**KIRKLEES METROPOLITAN COUNCIL
INVESTMENT & REGENERATION SERVICE**

DELEGATED DECISION TO DETERMINE PLANNING APPLICATIONS

Reference No:	2023/62/90936/W
Site Address:	102, Redwood Drive, Bradley, Huddersfield, HD2 1PW
Description:	Partial demolition and construction of new dwelling, detached garage and associated alterations
Recommending Officer:	Lucy Taylor

Officer Report.

PROPOSED PLAN

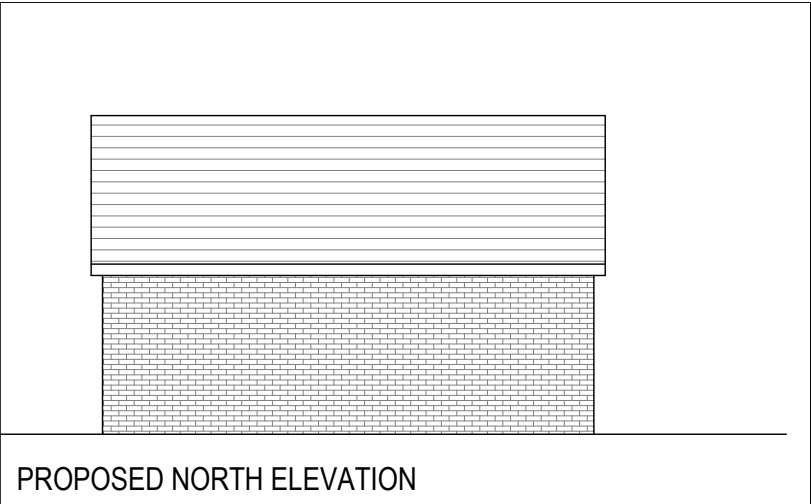
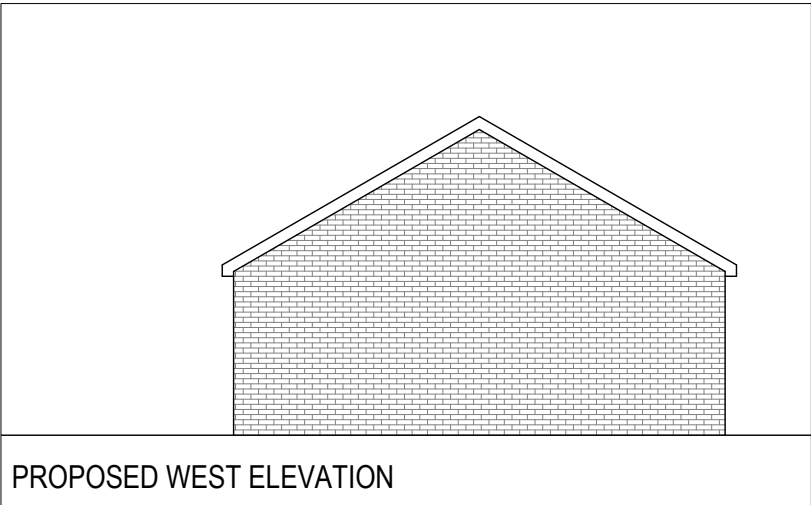
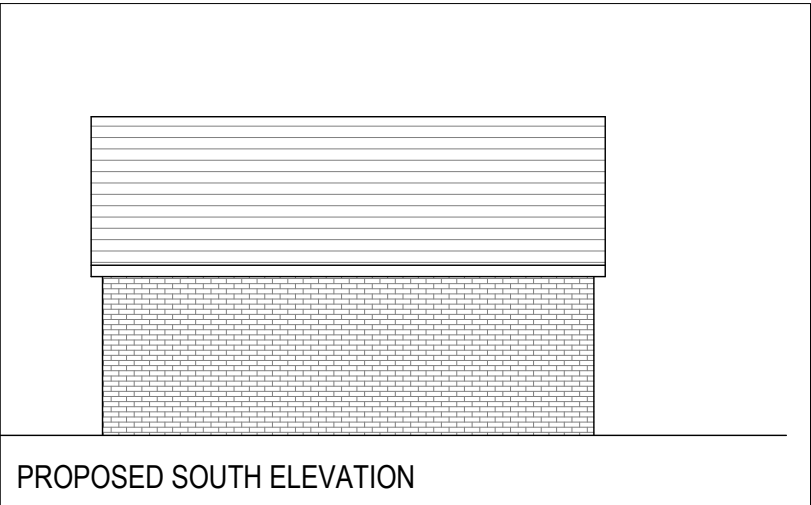
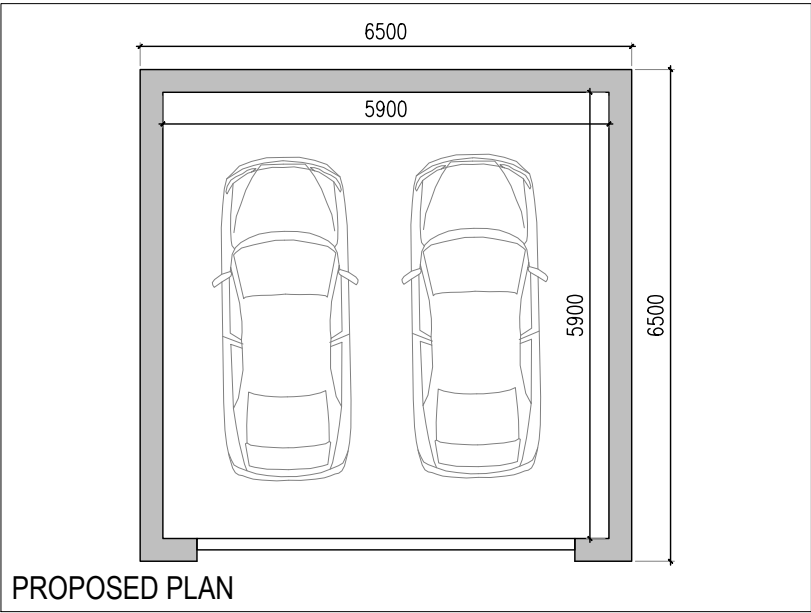
Furthermore, the detached garage could not be supported from a visual amenity perspective. This is concluded on the basis the garage would be set forward of the principal elevation of the new dwelling and, in conjunction with the proposed driveway, would see the loss of entire front garden amenity space leading to a parking dominated frontage.

The siting of the detached garage would be contrary to the requirements of Principle 12 of the Housebuilder Design Guide SPD, which sets out that garages should be set back from the front of the house and is not a dominant feature, as well as the requirement that vehicular parking does not dominate the front amenity space.

PROPOSED EAST ELEVATION

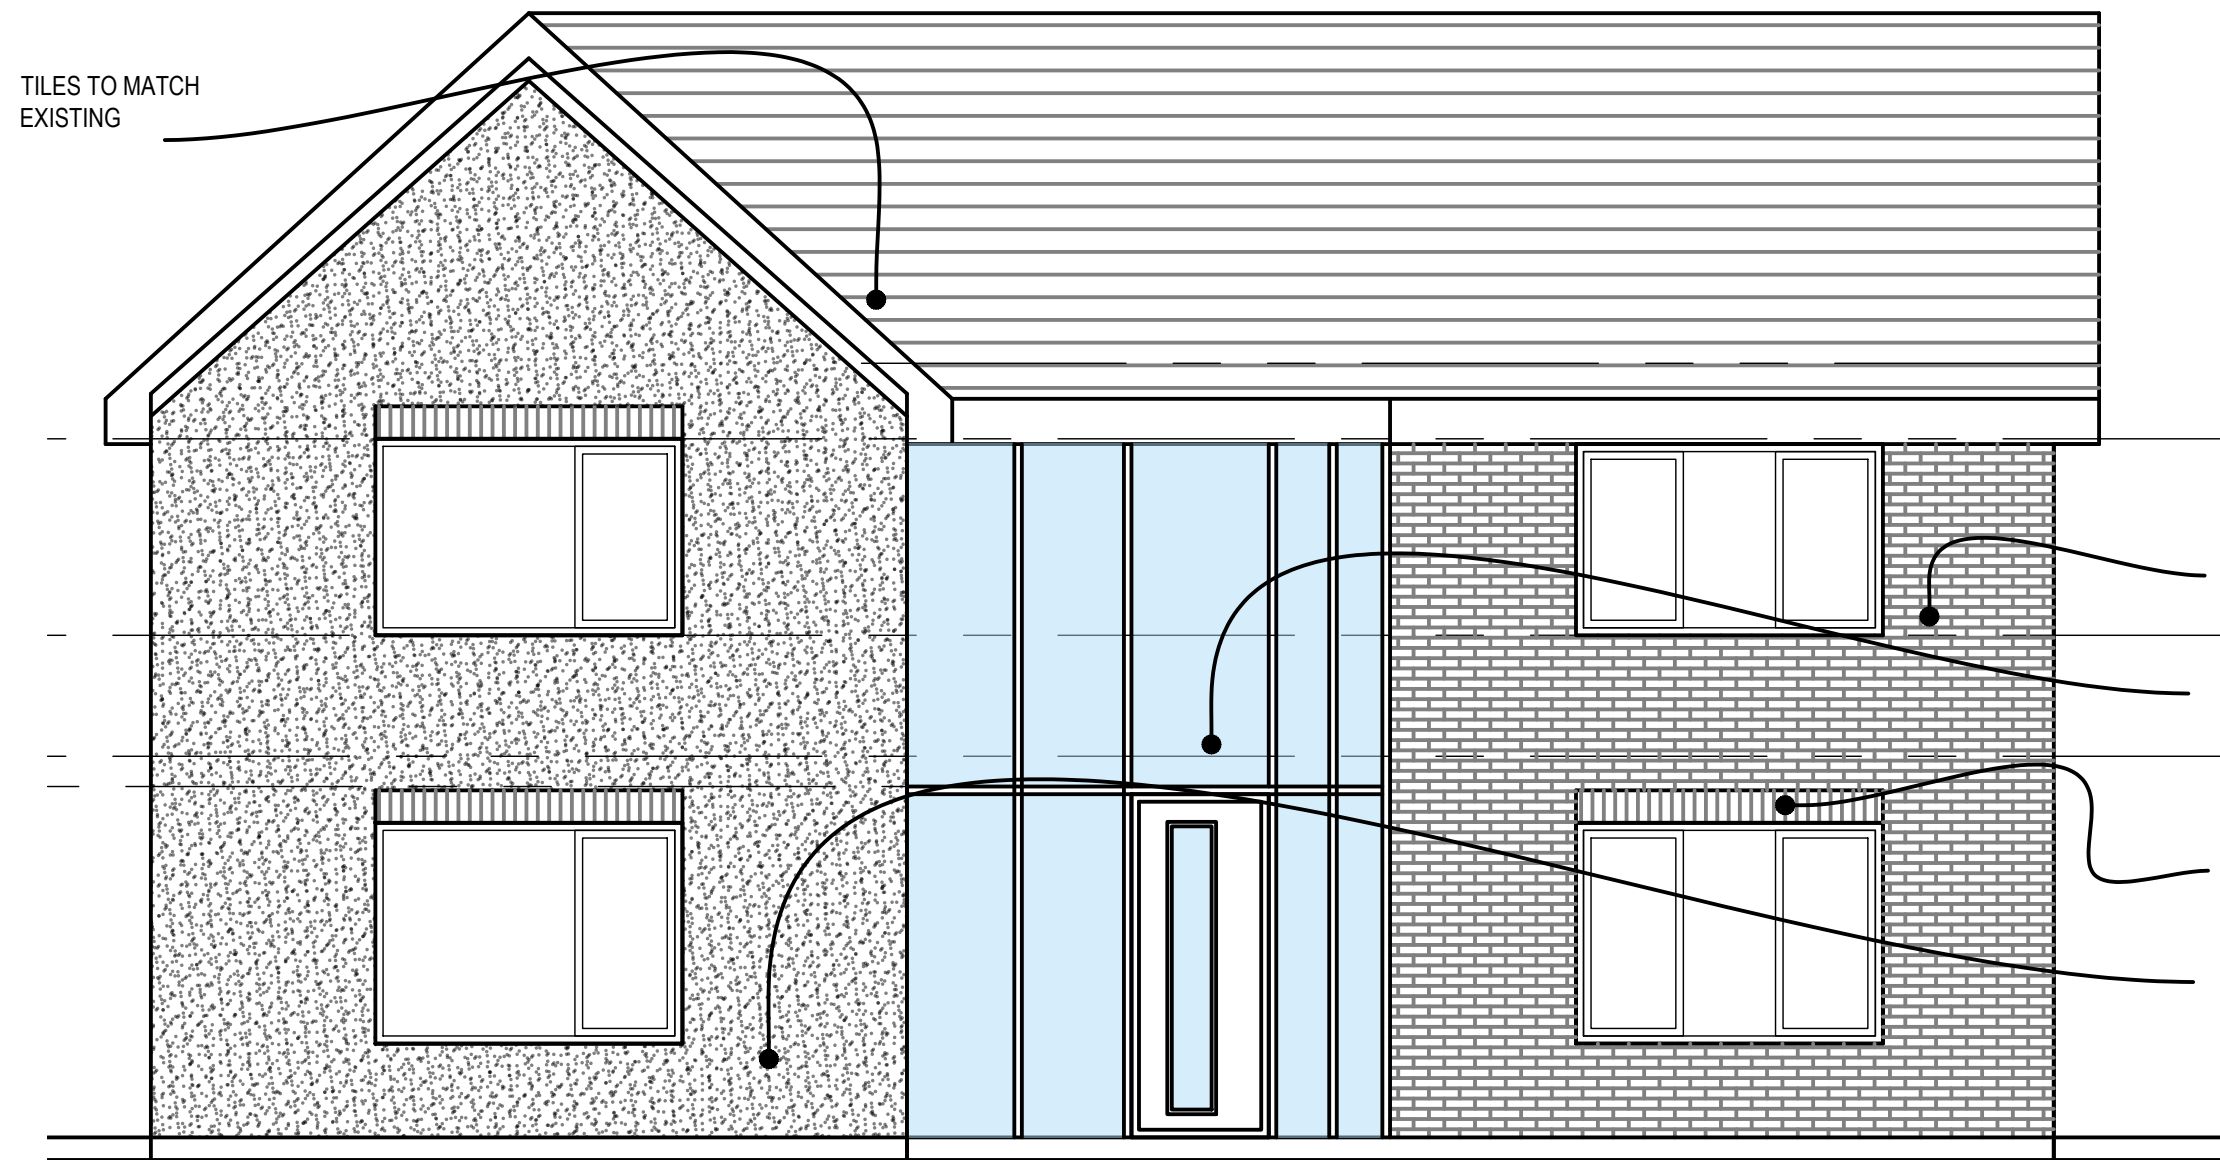
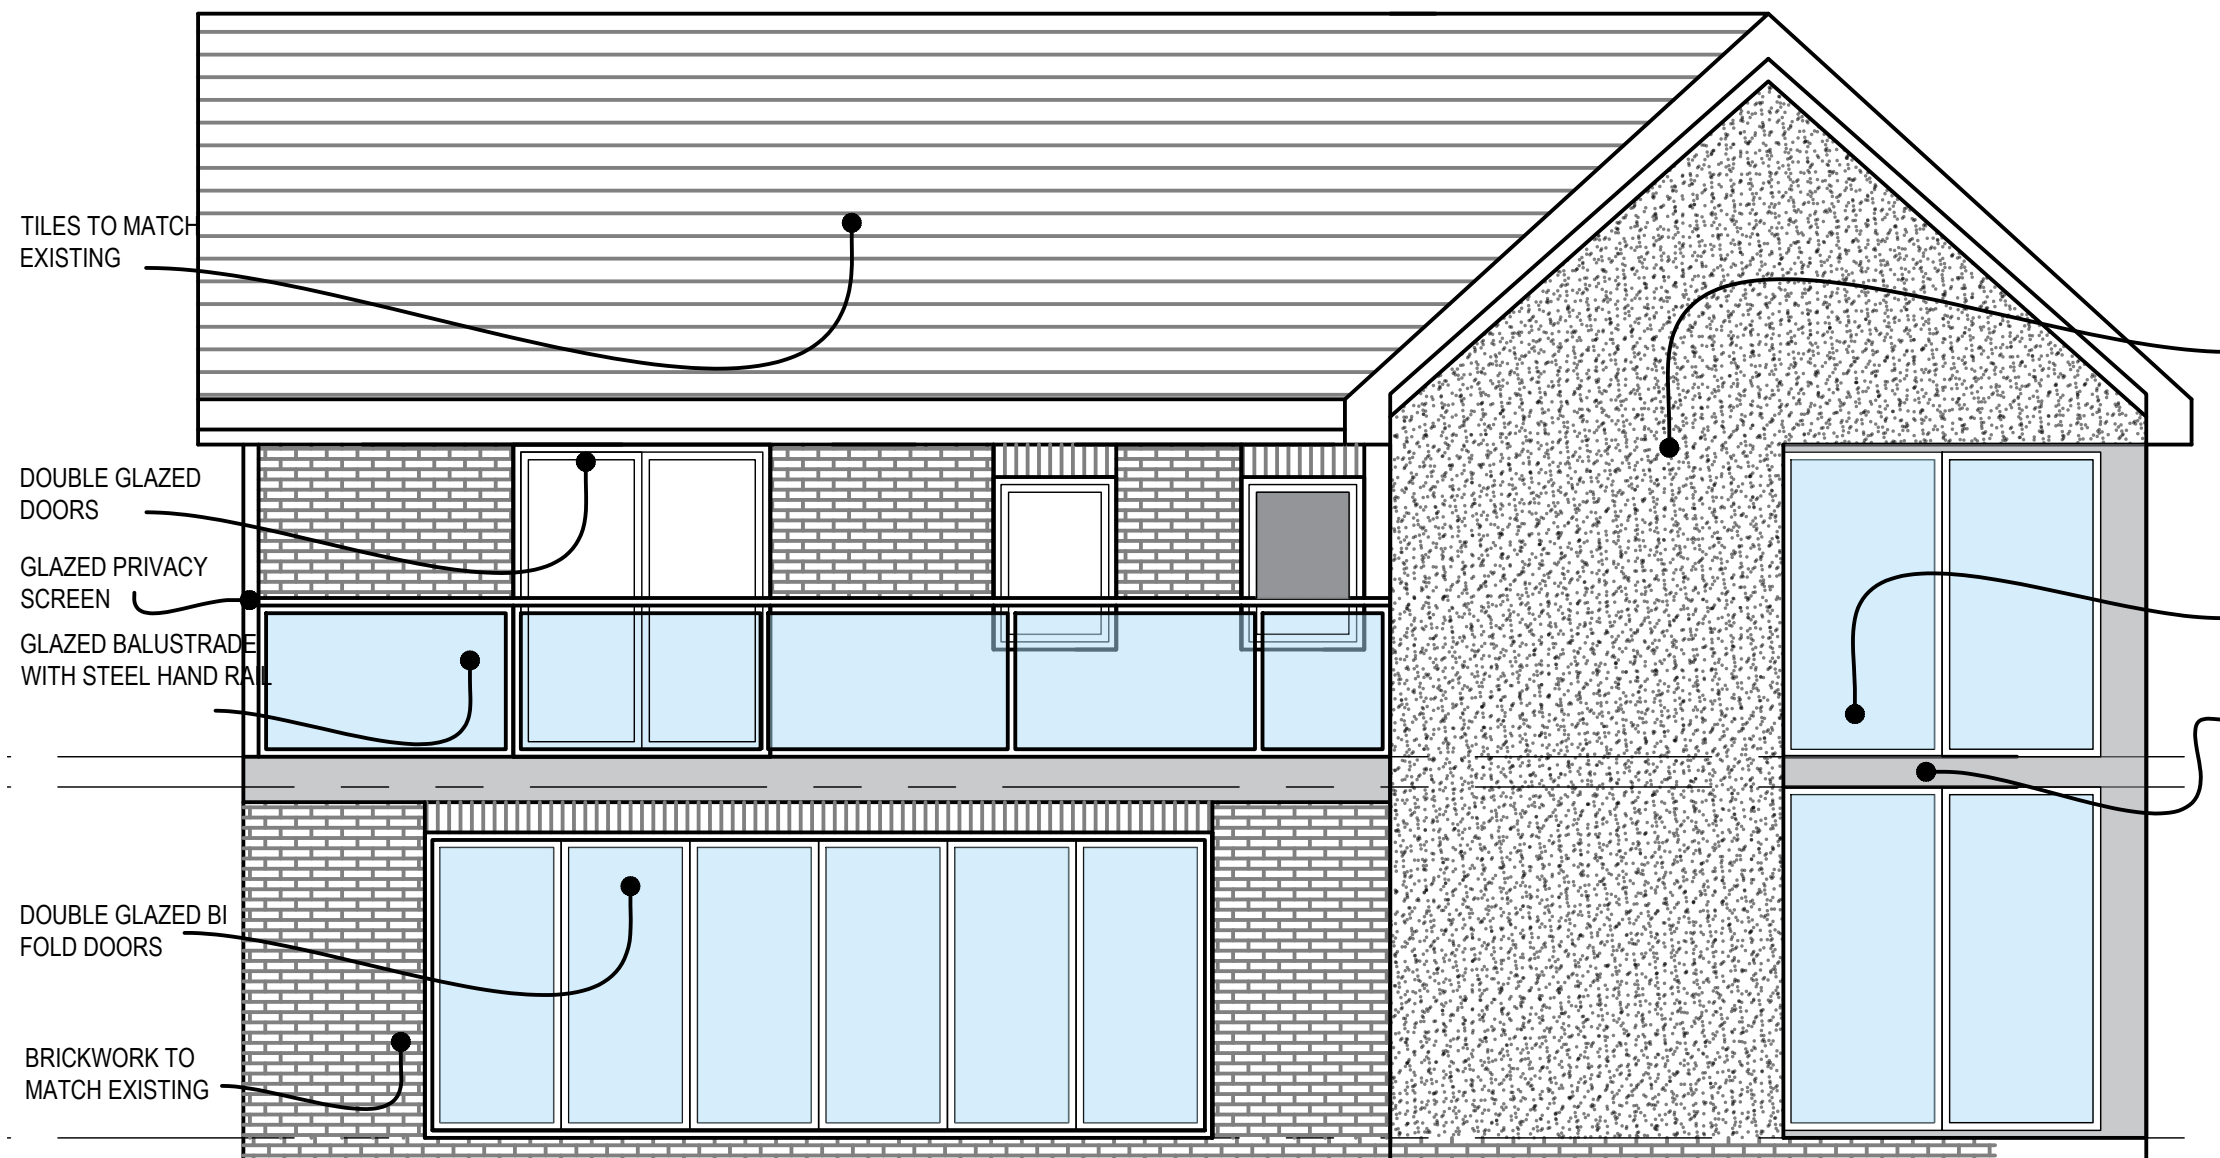
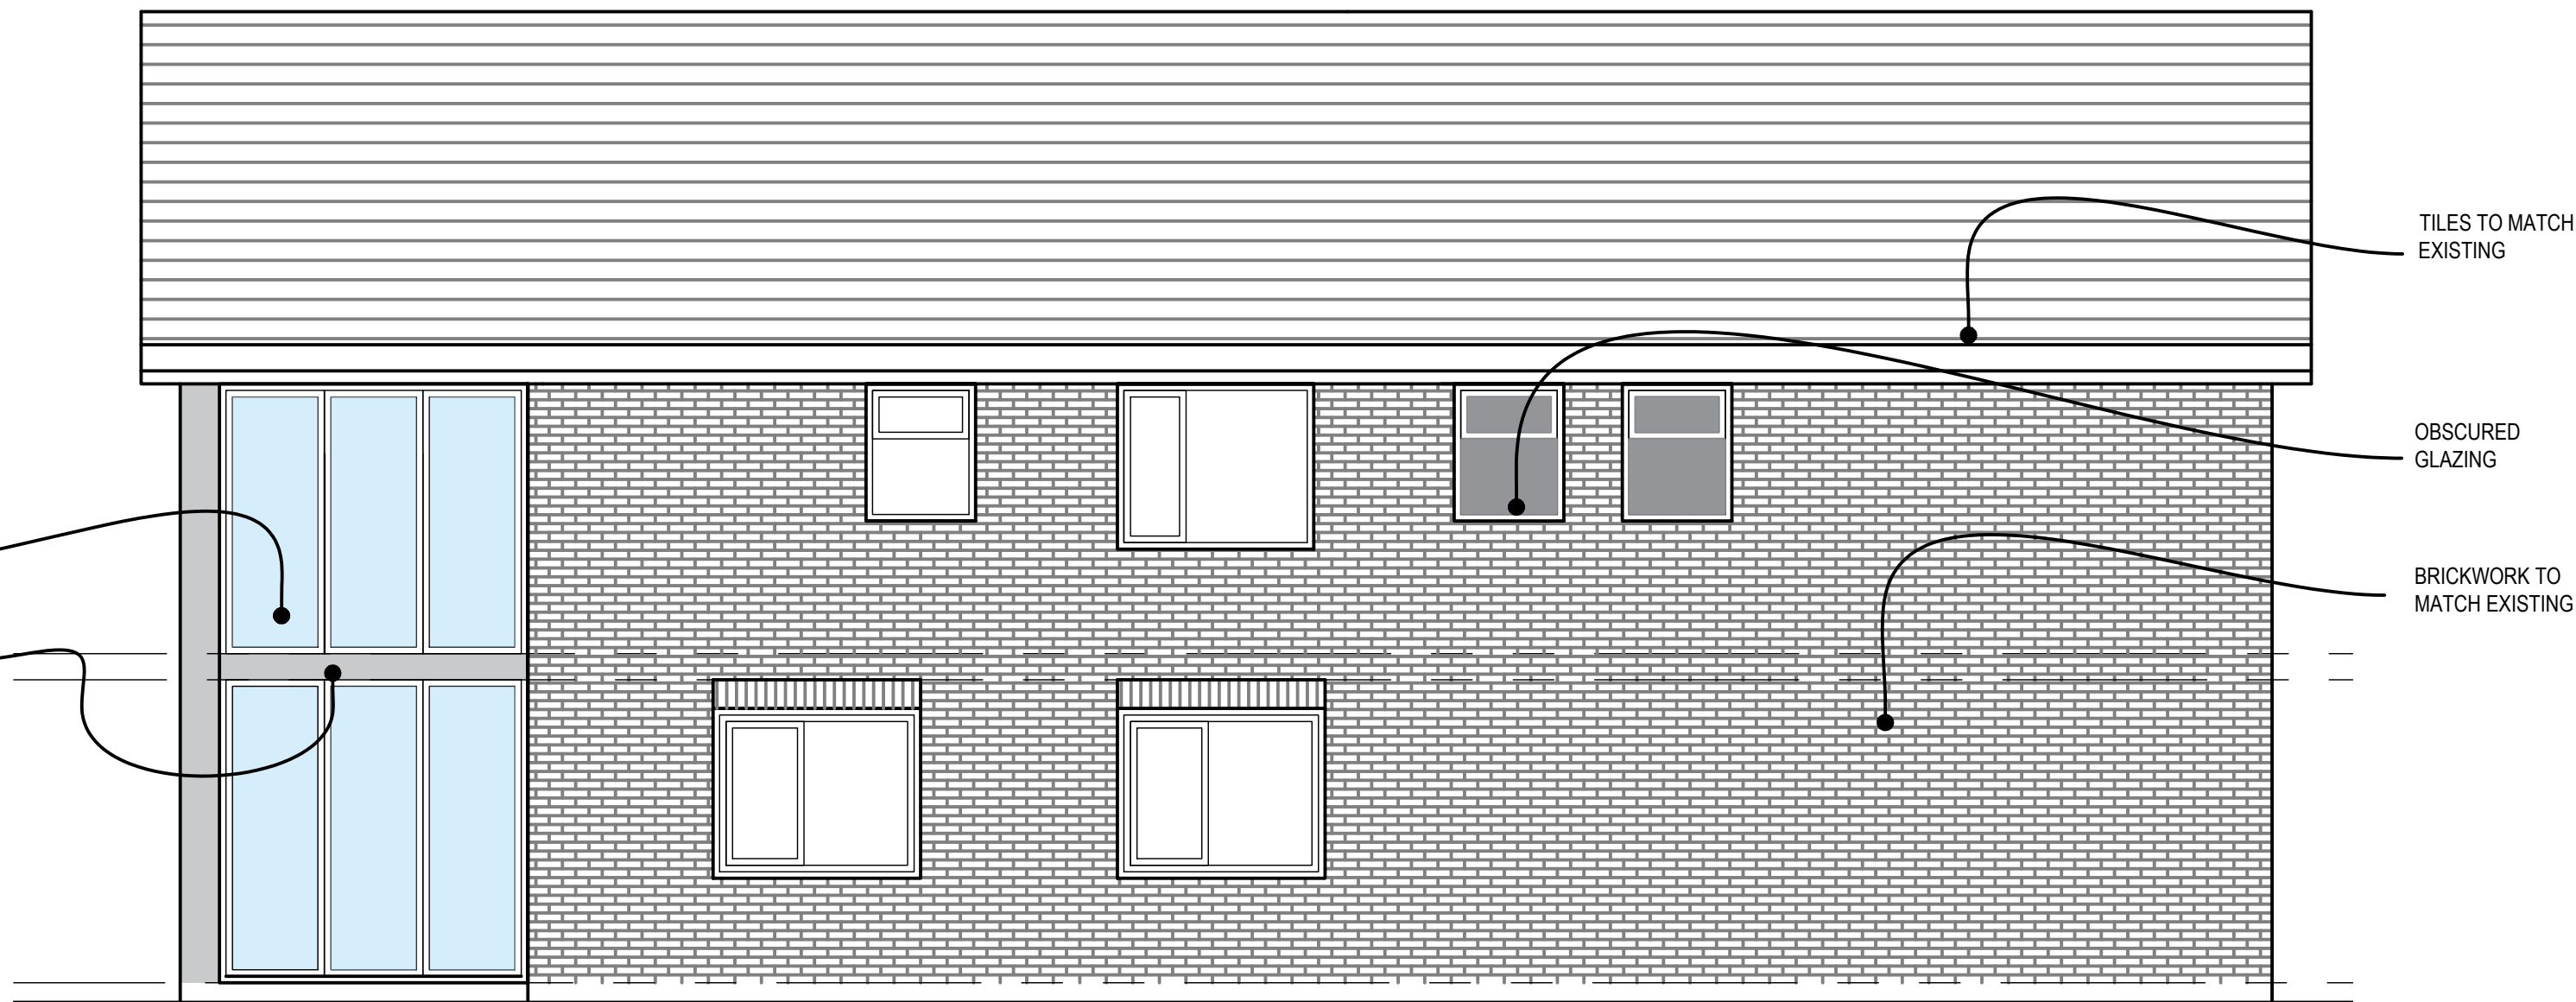
Firstly, the new dwelling would extend significantly forward of the original elevation of the existing dwellinghouse by 3.4 metres at a two-storey height of 7.6 metres. This forward projection would disrupt the building line of the original dwellinghouse and cause significant levels of undue bulking and massing to the front of the building. In addition, as well as causing adverse visual impacts to the host property, this forward projection would also cause wider impacts by disrupting the established building line within the streetscene with regard to the neighbouring properties direct southwards. In turn, this forward projecting gable element would be contrary to Principle 5 of the Housebuilders Design Guide SPD, which emphasises the importance of a coherent building line.

The undue levels of bulking/massing to the frontage of the site would be exacerbated further by the out-of-keeping appearance of the principal elevation. The significant extent of white render and full height glazed atrium entrance lobby would not harmonise with the character of the original property, which was faced in brick with a very minimal extent of render detailing. The neighbouring properties are faced entirely in brick to the principal elevations. In turn, the design of the principal elevation of the new dwelling would be contrary to Principle 2 of the Housebuilders Design Guide SPD, which emphasises the importance of creating a positive and coherent identity with regard to materials and appearance.

Officers note that the proposed plans show new glazing to be installed to the northern side elevation of the property, with double height glazing and regular windows to serve habitable rooms internally, including bedrooms.

Given the nature of the coffee house, as well as the other surrounding uses, it is considered that the Priority Employment Area could produce levels of odour and noise that would detrimentally impact upon the occupiers of the proposal as a result of the introduction of glazing on the northern elevation of the new dwelling.

No details of noise or odour pollution from the Priority Employment Area were submitted as part of this planning application. Therefore, it is concluded that insufficient information has been provided with regard to impacts of noise or odour with regard to the introduction of new glazing to the northern elevation of the dwelling.
